Application for a non-material amendment following a grant of planning permission.

ERECTION OF A SINGLE STOREY REAR EXTENSION
TO DWELLING.

2016/0111

REDUCTION OF EXTENSION TO AVOID GAS MAIN

Drawing Number:	2CS-02	Revision:	A
-----------------	--------	-----------	---

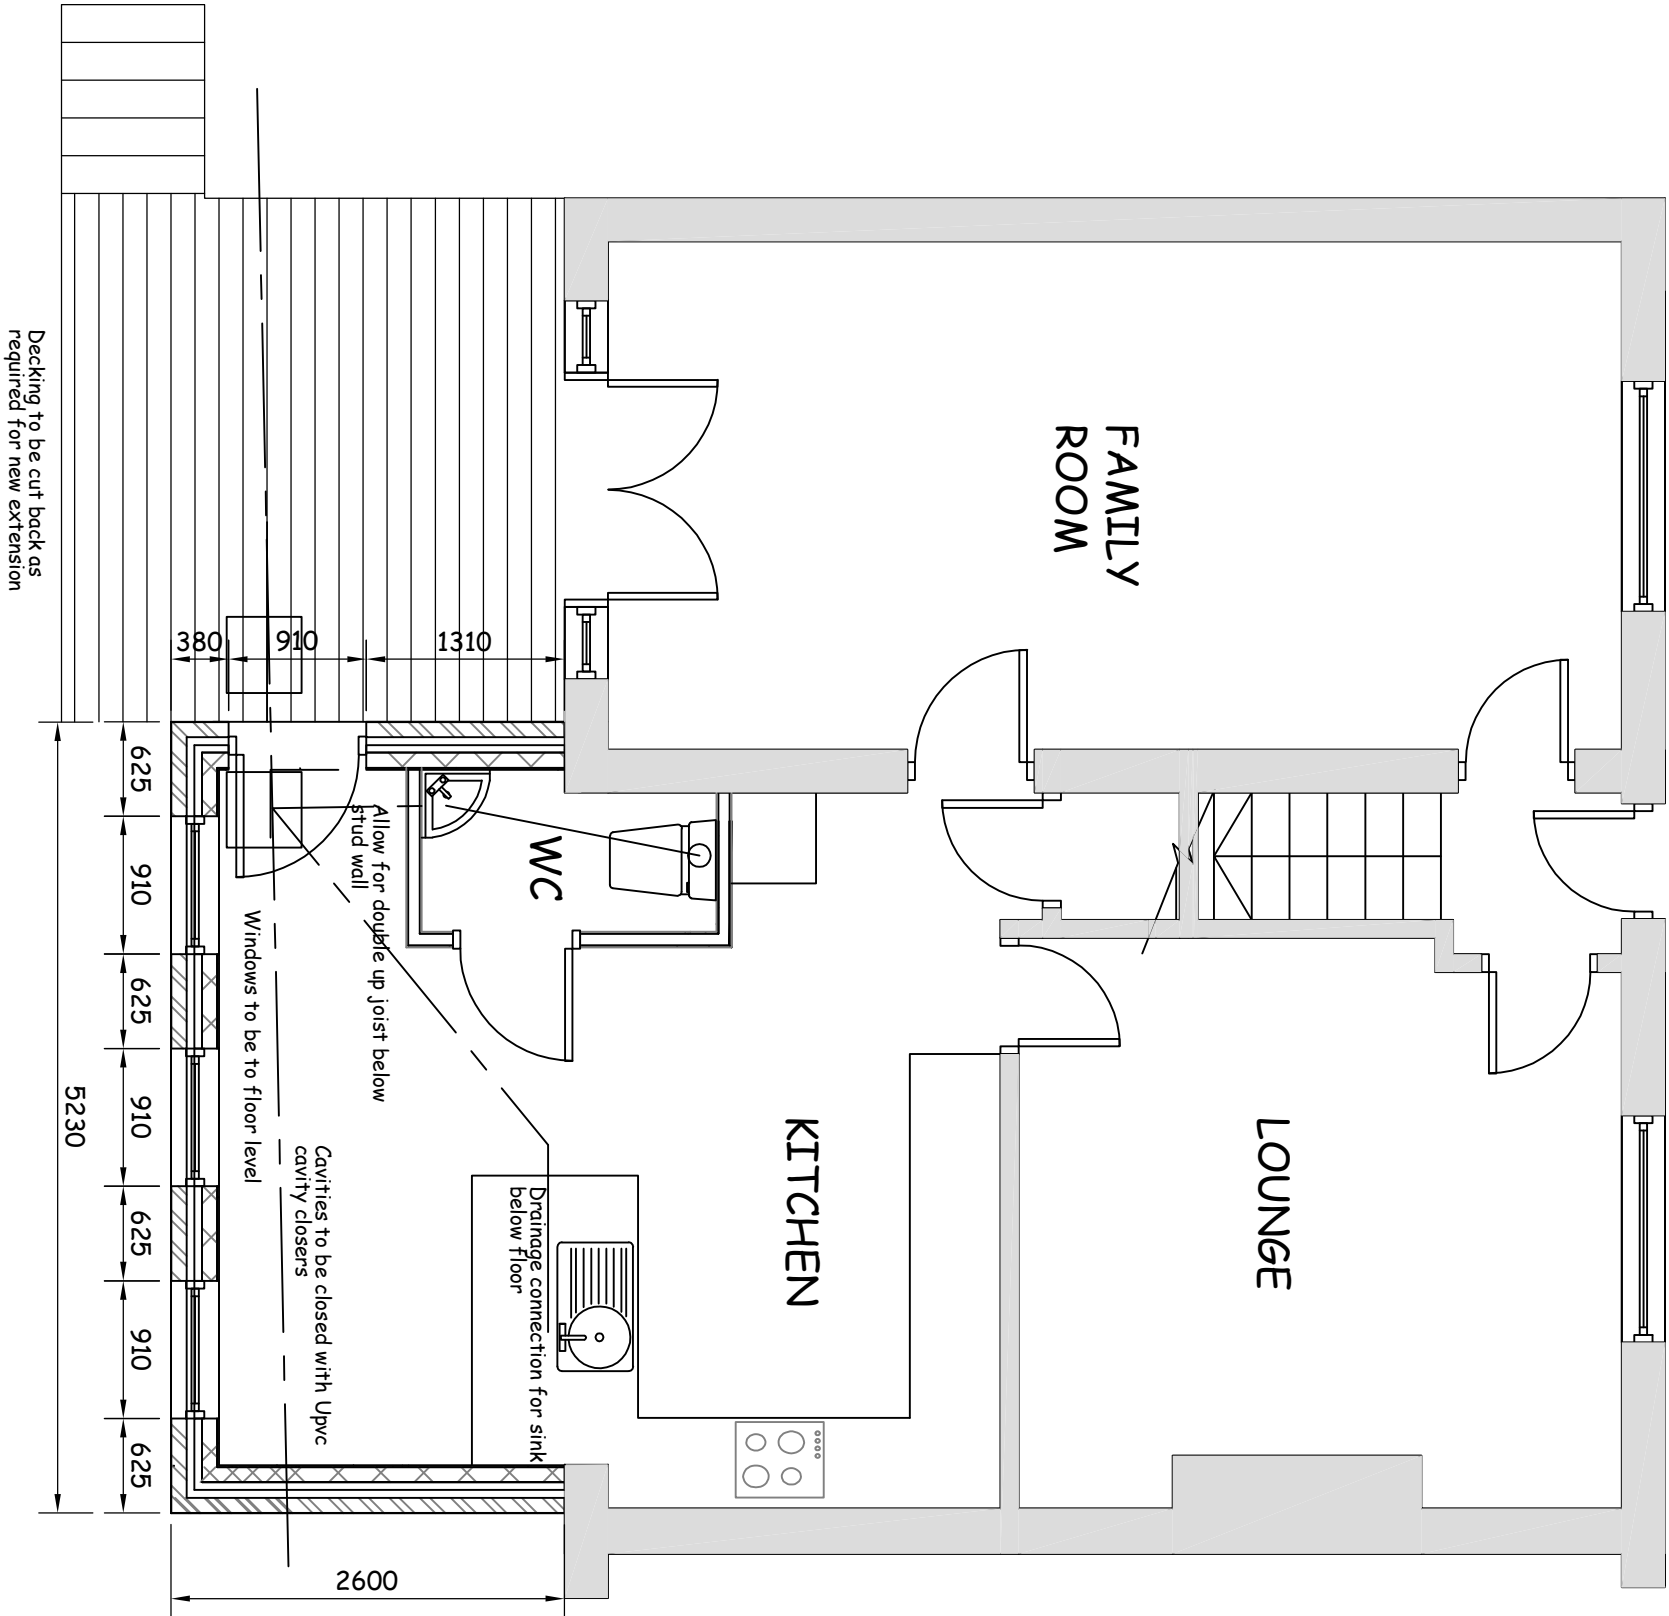
TO AVOID CONFLICT + DIVERSION OF GAS MAIN.

2CS-02 REVA, 03 REVA + 04 REVA.
